**KIRKLEES METROPOLITAN COUNCIL
INVESTMENT & REGENERATION SERVICE**

| Reference No: | 2024/62/91386/W |
| Site Address: | 62, Crosland Road, Oakes, Huddersfield, HD3 3PA |
| Description: | Demolition of existing garage and erection of single storey rear extension |

Client	Mr Usman Majid	Issued From	
Project	2461 : 62 Crosland Road : Domestic Extension	Date	May 2024
Title	Proposed Site and Ground Floor Plans	Scale	1:50 & 1:100 @ A1
Drawn	BH Auth BH	Revision

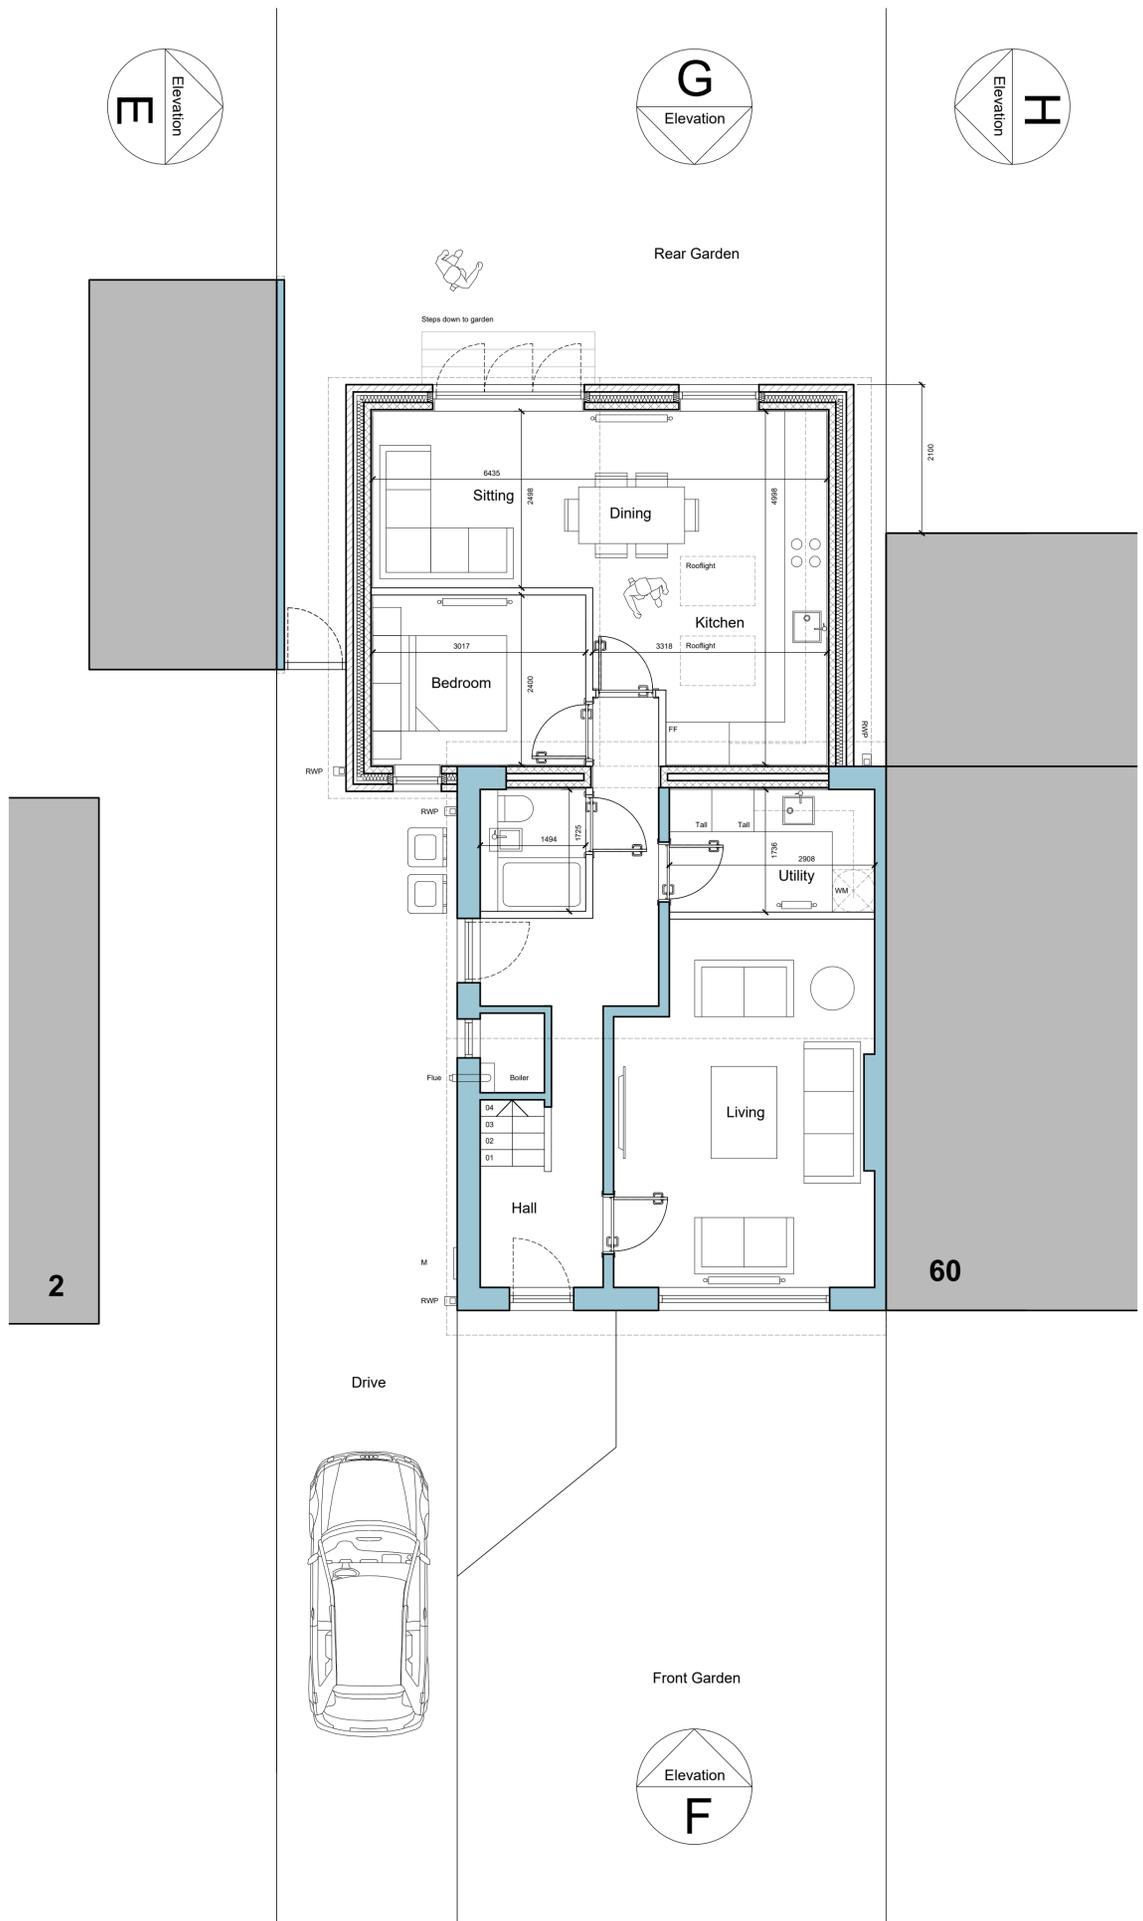
| | YES / NO | SUMMARY |
|--|-----------------|---|
| Negotiations/Amendments during course of application | Yes | The agent was contacted regarding the proposals and elements not meeting the recommendations of the House Extensions and Alterations SPD. It was recommended that consideration be given to reducing the scale of the extension by aligning the rear elevation with that of the adjoining property’s extension and also keeping in line with the side elevation of the host property. |

The applicant seeks permission for the erection of a single storey rear extension. The extension would project 5.6m from the rear and have a width of 7.1m. The roof form will be a dual pitched roof with an eaves height would be 2.5m with an overall height of 3.85m. Construction materials proposed are buff brickwork walls and concrete roof tiles to match the existing property.

| Rear extensions should: | <u>Yes - COMPLY</u> | <u>No - JUSTIFY</u> |
|--|---|--|
| Be set behind the original building, and not projecting beyond the sides | | No – the extension would extend beyond the side elevation by 1.58m. However, in this isolated case this is considered acceptable due to the house being situated at a significant distance away from the street (24m) meaning it |

| not project out more than 3 metres from the rear wall of the original house for semidetached and terraces houses or by 4 metres for detached properties | | No - the projection from the rear wall is 5.6m. However, this is considered acceptable due to the large size of the plot and the relatively low eaves height as well as the projection of an extension to the adjoining neighbour. |

| <p>retain a gap of at least 1 metre from a property boundary, such as a wall, fence or hedge</p> | | <p>No – the extension would only be situated 0.45m from the boundary line to the southeast and 0.8m to the northwest. However, on the southeast boundary due to the neighbouring property having a 3.5m extension and then a ~2m hedge along the boundary line and to the northwest due to the neighbours garage running along the majority of this boundary leads to the conclusion that a 1 metre gap is not considered to be necessary in this case and it is considered it would be unreasonable of the LPA to insist upon this space being maintained / provided for as part of this application.</p> |

| Window proportions | <ul style="list-style-type: none"> • KDP 1 and 2 of the SPD • Policy LP24 Design (a), (c) and (d) of the KLP • Chapter 12 of the NPPF | No openings are proposed in either side elevation. The proposed rear elevation (east) includes one window proportionate to window sizes on the original dwelling and bifolding door. | |

| Impact on light and outlook of neighbours (to sides, rear and front) | <ul style="list-style-type: none"> • KDP 4, 5, 6 of the SPD • Policy LP24 Design (b) • Chapter 12 of the NPPF | <p>With regard to No.60 the projection is 2.1 metres (taking account of the existing extension to the adjoining neighbour). The proposed extension is no more than 4 metres in height, whilst the proposed extension is close to the boundary, boundary fences can be 2 metres in height in any event and a large hedge already exists at ~2 meters.</p> <p>Therefore the proposal is not considered to be overbearing.</p> <p>In regard to loss of light the extension is almost directly west of the neighbouring property which means the extension does not overshadow the neighbouring conservatory from direct sunlight at any time during daylight hours in winter months and only marginally in evening hours during the summer months. Therefore, loss of light is not considered to such that it would constitute ground(s) for refusal. Due to No.2 being at a higher land level and having an existing detached garage</p> | ✓ |

| | | The agent responded with justification for the original scheme. |
